5th January 2024

The Planning Inspectorate
National Infrastructure Directorate
Temple Quay House
Temple Quay
Bristol
BS1 6PN

Sunnica EN010106

Appendix 2 - Detailed ALC map

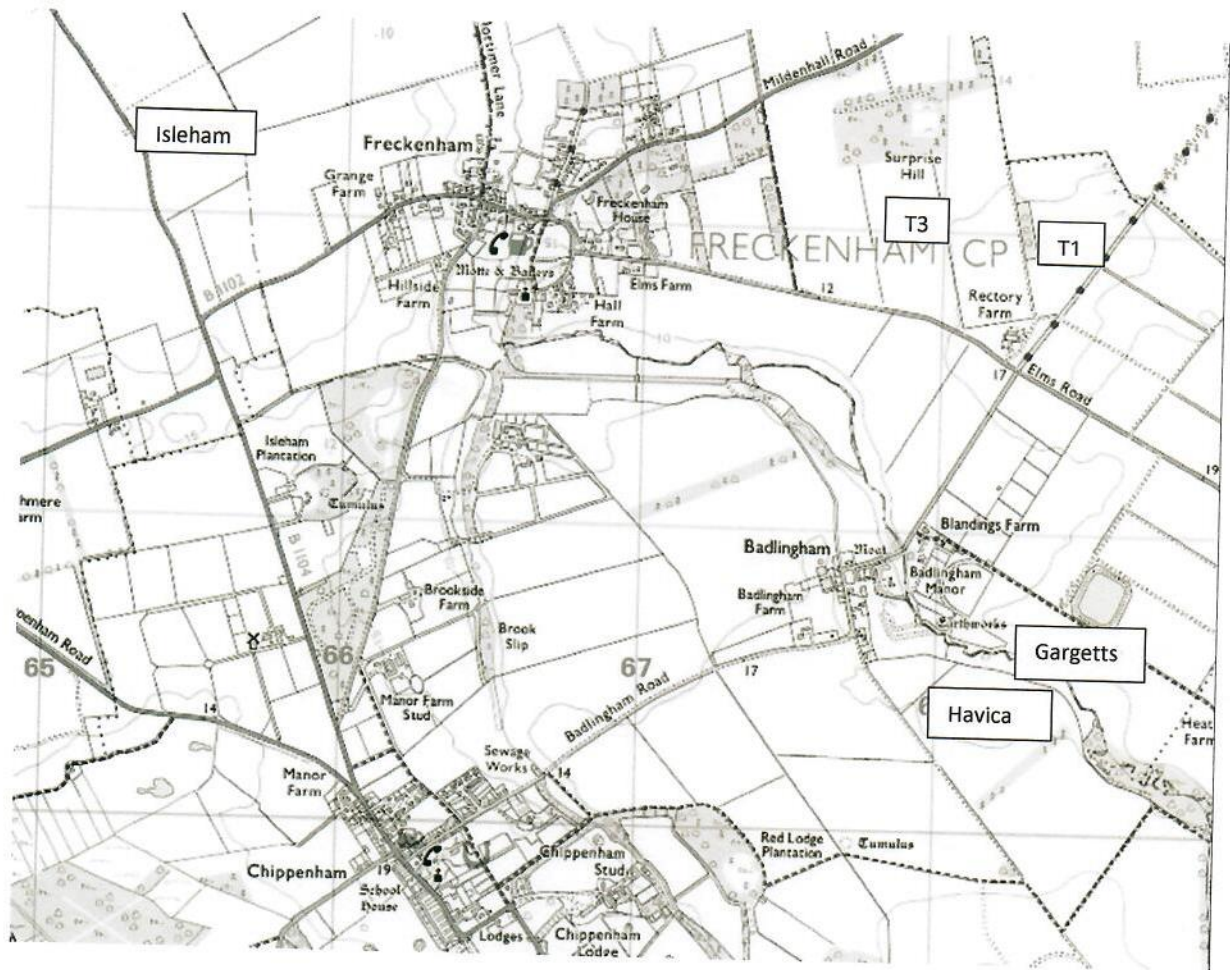
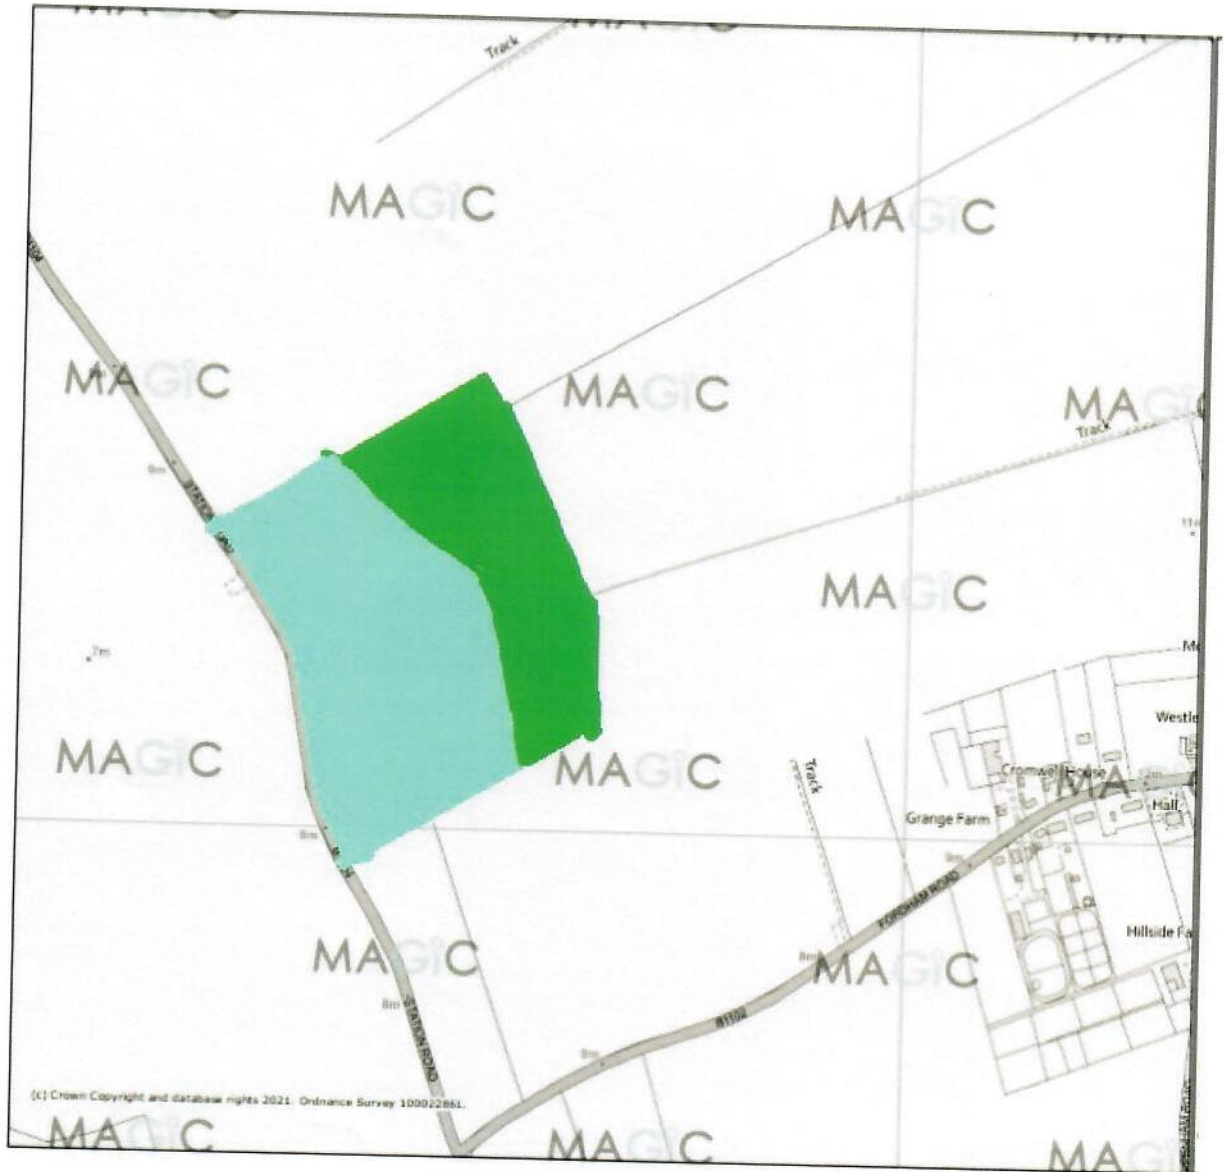
- Given the inability of the undersigned to gain access to the application area in order to carry out a second, independent soil survey of selected areas, our analysis relies in part on highly detailed mapping of soils of the area carried out by MAFF and the Soil Survey of England and Wales. Although these surveys were carried out in the 1960s, soil profiles which have been in situ for 12,000 years will not have undergone any significant changes over the last 70 years that could affect their ALC grade. The findings of these surveys concur with the findings of surveys undertaken by ADAS and Reading Agricultural Consultants relied upon by Sunnica, but they do not agree with the findings of DBSC on the land surveyed on behalf of Sunnica Ltd.

- With the obvious concerns regarding the inconsistencies between the findings relied upon by the DBSC report and the published authoritative small-scale mapping, the land should have been resurveyed to confirm the survey results. We are unsurprised that the applicant landowners resisted repeated requests for access as significantly more than 1% BMV would have been identified across the site.
